From: Maria Tomalova <Maria.Tomalova@arun.gov.uk>
Sent: Wednesday, September 13, 2023 5:54 PM
To: Planning.Responses <Planning.Responses@arun.gov.uk>
Subject: FW: Y/105/19/PL and Y/106/19/L, Stakers Farm

From: Maria Tomalova
Sent: Thursday, June 18, 2020 12:59 PM
To: Ben Daines <[REDACTED]>
Subject: Y/105/19/PL and Y/106/19/L, Stakers Farm

Please see below Martyn's comments in red and mine in green.
(your email from 22nd May 2020)

Drawing Title	Proposed Plans - Barn 3
Scale	1:100 @ A3

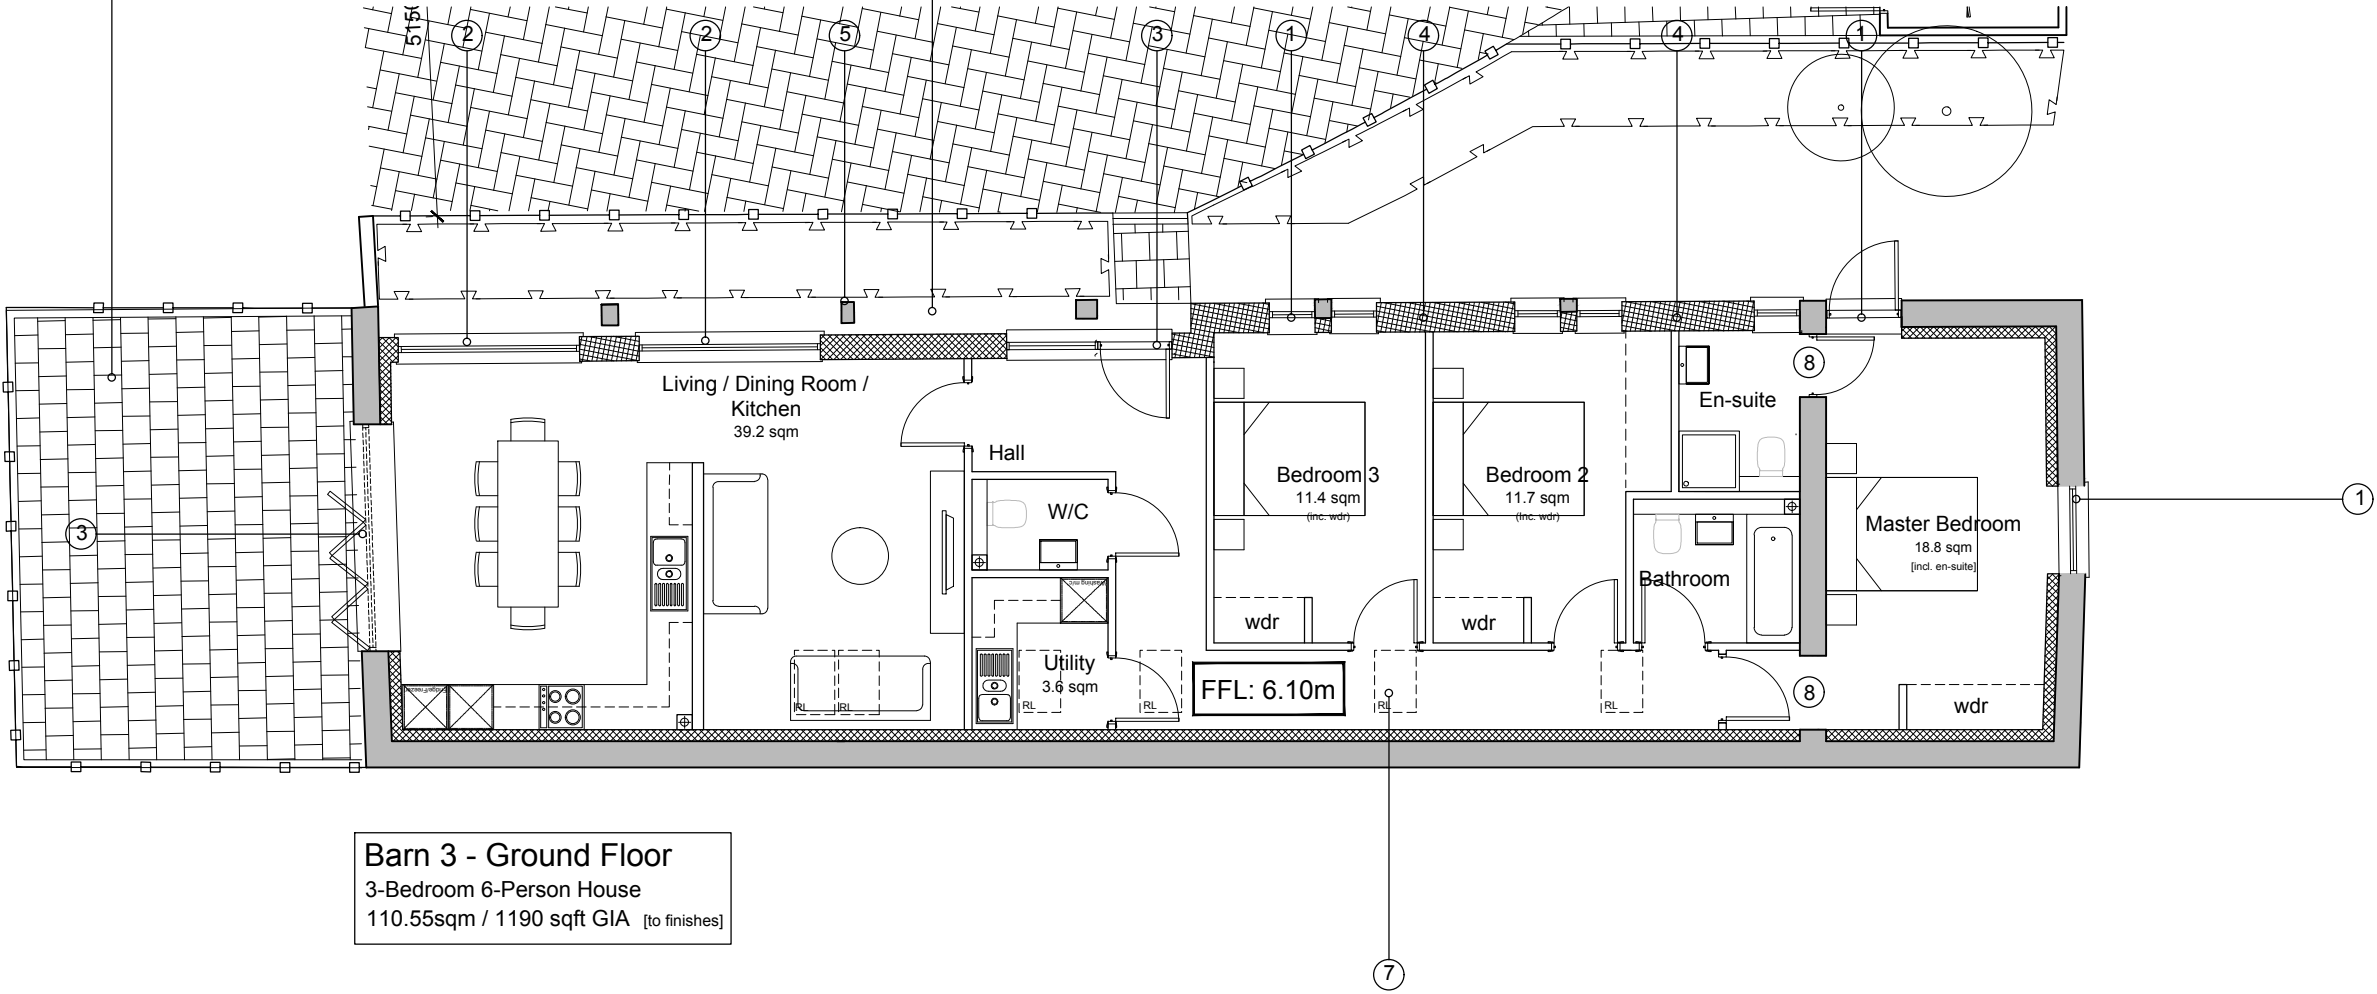
As I recall, no amendments to the drawings were required for this barn – previously there was a bi-folding door, but I believe this is to be removed?

Proposed North-West Elevation (A)

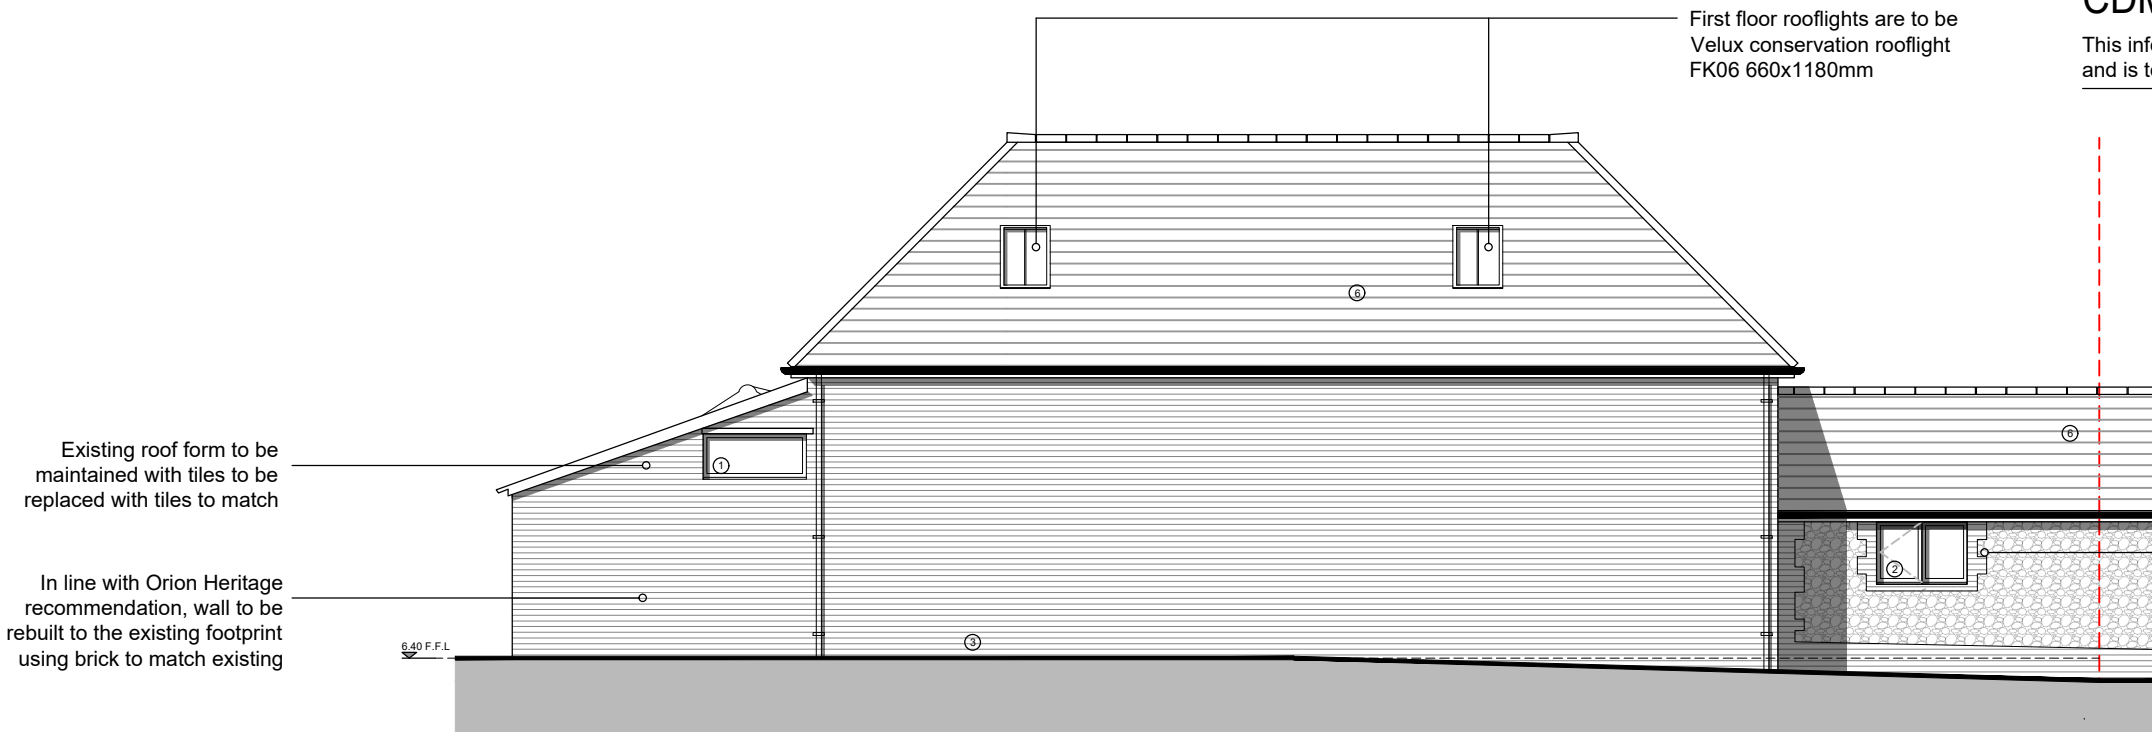
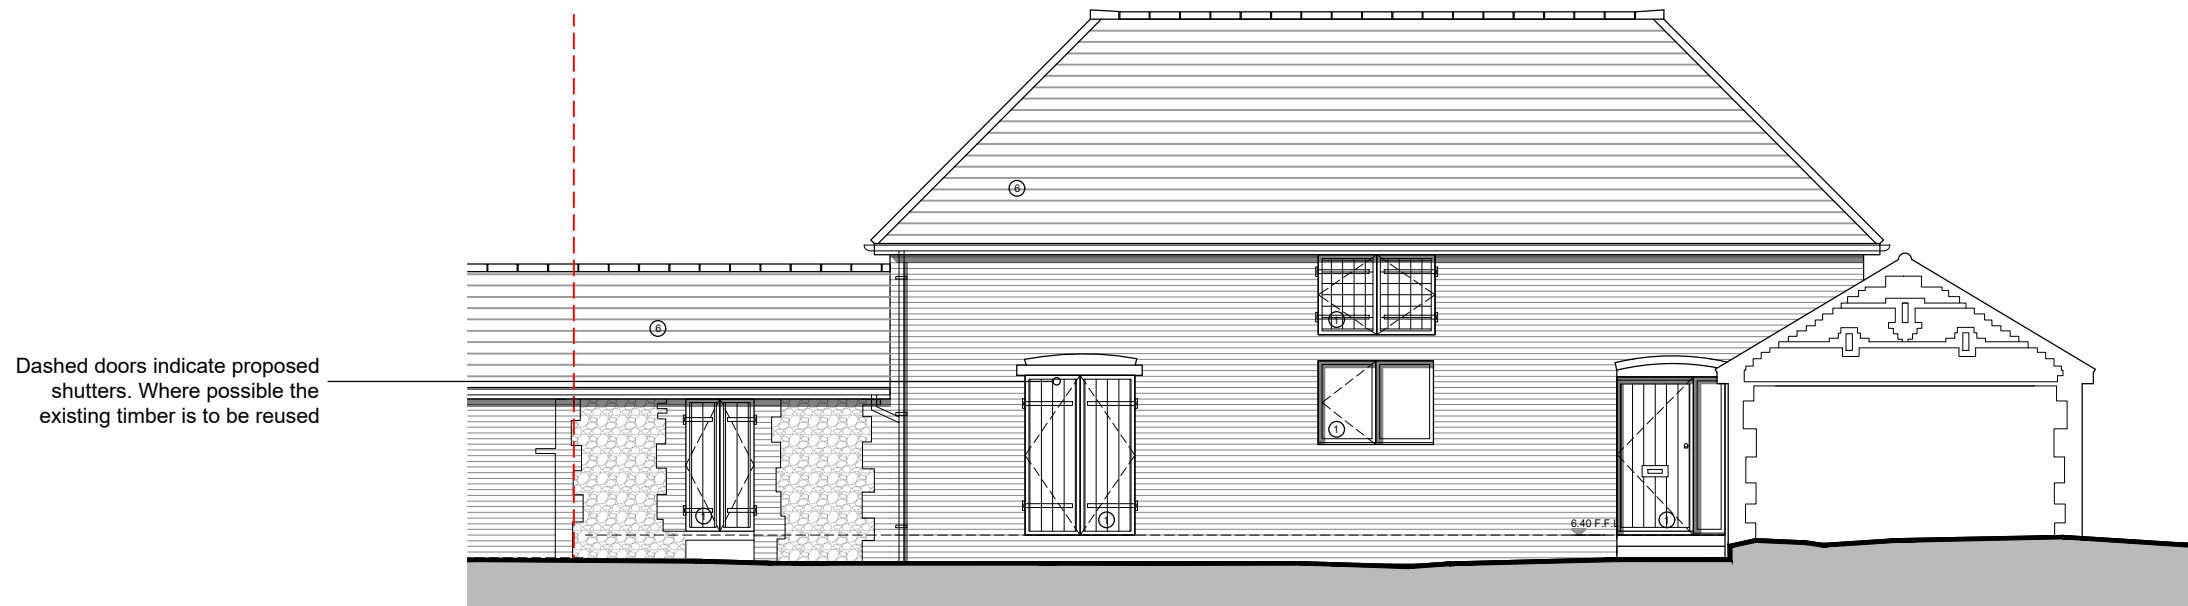
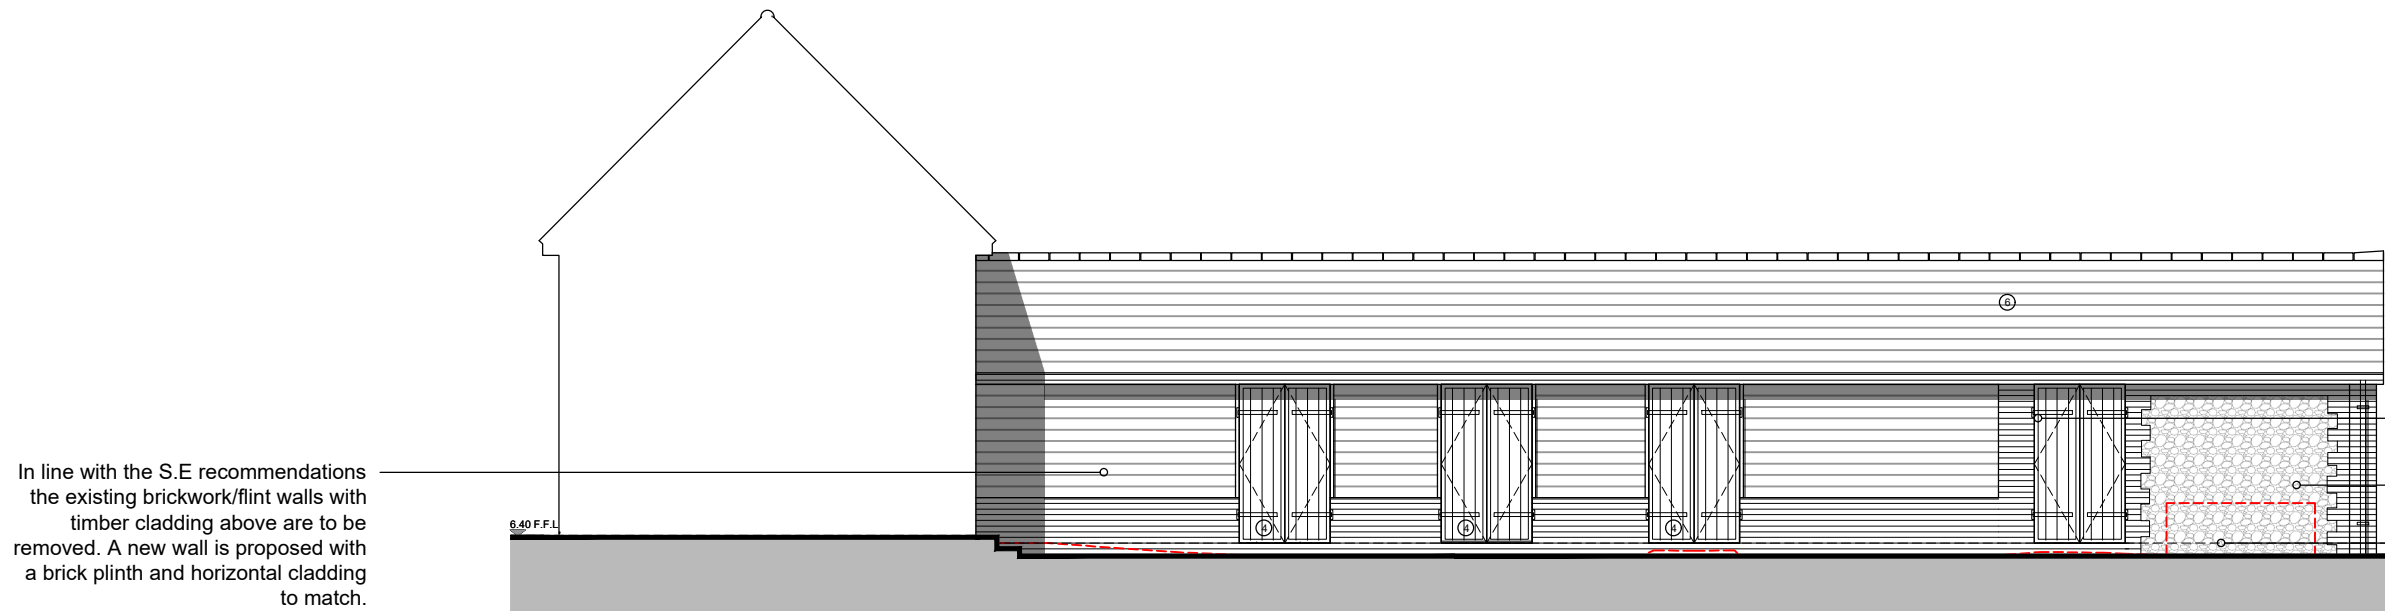
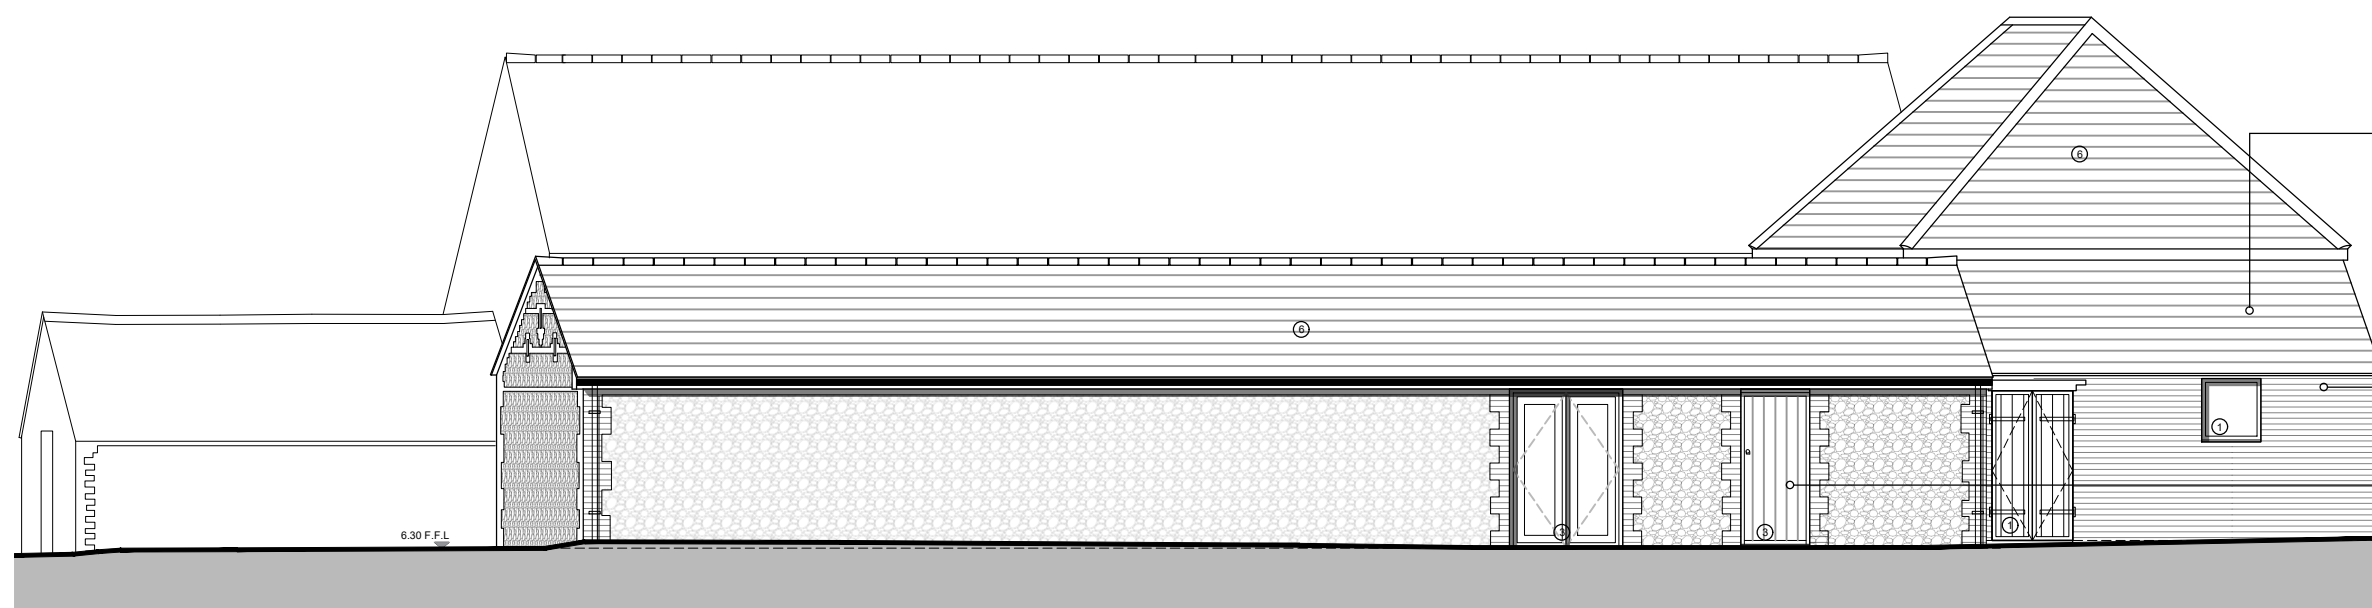
South elevation – we will amend the proposed alterations to the single storey element and reduce the amount of glazing, ensuring that this elevation is changed as little as possible from the existing situation.

There should be as few rooflights as possible, and these should be placed on the rear elevations where they will not be visible. They should also be of conservation standard. No roof-lights on primary elevation. A casual glance should not reveal that the building has been converted. This means that unconventional arrangements of rooms are required. Roof structures comprise a dominant visual feature and should be left uninterrupted.

It is not clear how the interior of the barn will be treated, bearing in mind the comments I previously made regarding the interior. This needs careful consideration and more information to be supplied to us

We will remove as many rooflights as possible from this barn. However, we cannot remove all the rooflights as we will need to provide light to the bedroom to make it a habitable space. A roof light will also be required to provide purge ventilation (Part F of Building Regs) otherwise a mechanical system would be needed. Under the Building Regulations we will also need to meet the Daylight and room brightness guidance set within British Standard BS 8206-2:2008 Lighting for Buildings. We will therefore seek to provide the very minimum amount of rooflights necessary to meet Building Regulations and seek to locate them on the least prominent part of the roof.

Proposed East Elevation (B)

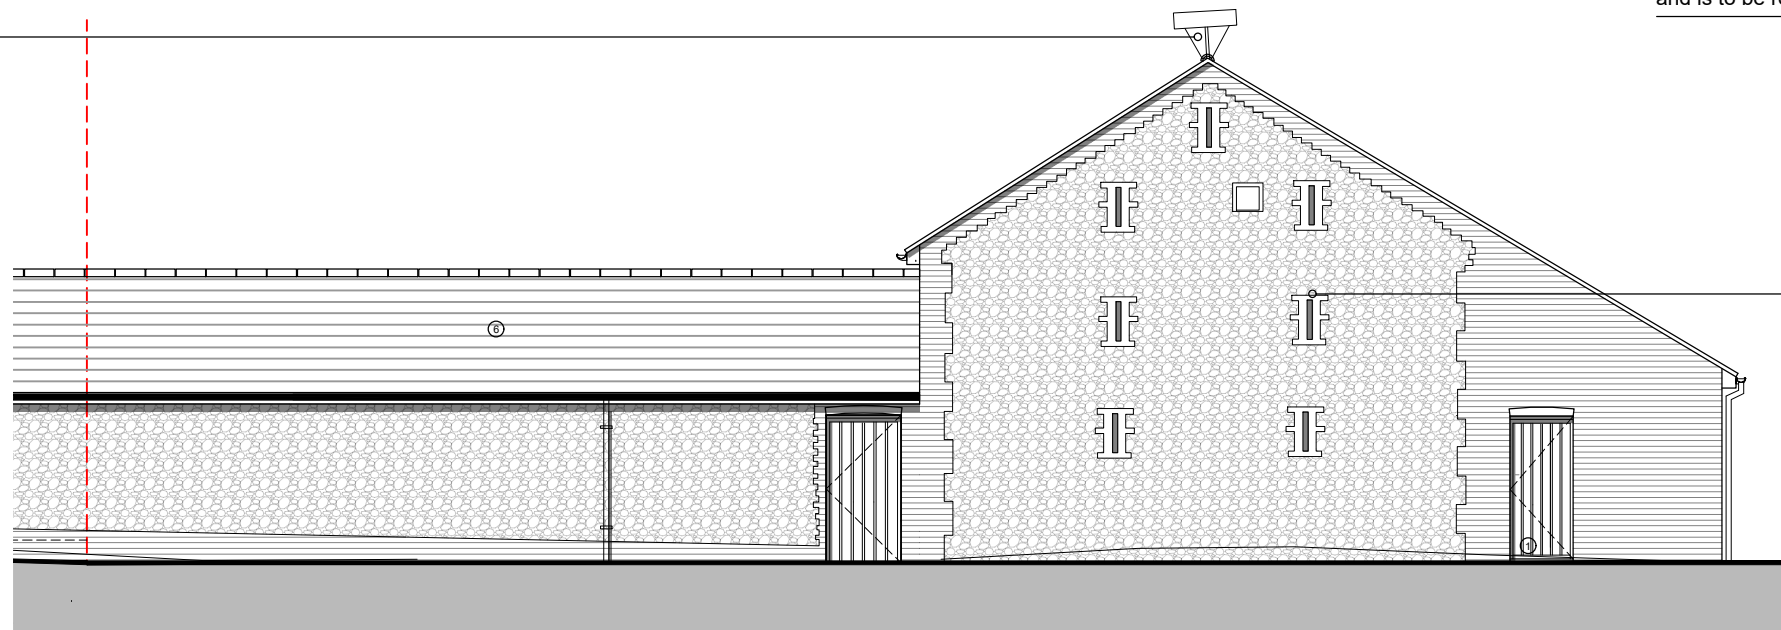
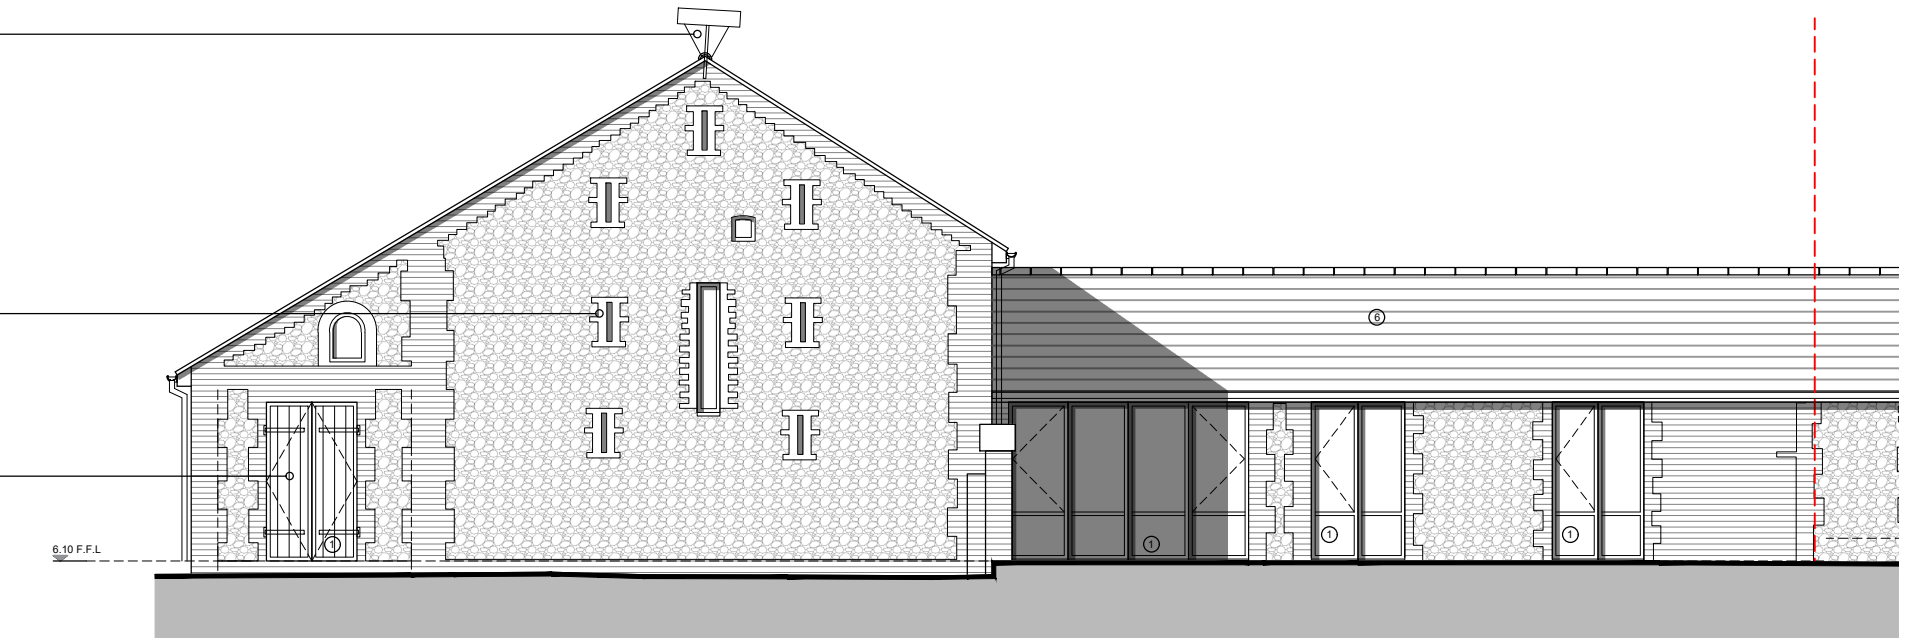
East elevation – we will ensure that the single storey element of the barn retains the features of the existing building as far as possible and will not reduce in size the larger existing opening.

East elevation – having regard to the two storey part of the barn, as discussed, we will have a look at how we can improve that part of the barn that was rebuilt at a later date and we will replace the existing unsympathetic door.

South elevation – we will remove all of the lower rooflights but will keep the higher ones. We will also reconsider the French doors.

North elevation – we will reduce the number of rooflights as agreed. Flash may be acceptable if no alternative exists. As far as I remember we have agreed with one exception in the north-western end of the roof plane.

North-west elevation – we will seek to retain the small existing window by the door and retain the existing door in the single storey element rather than installing a new door.
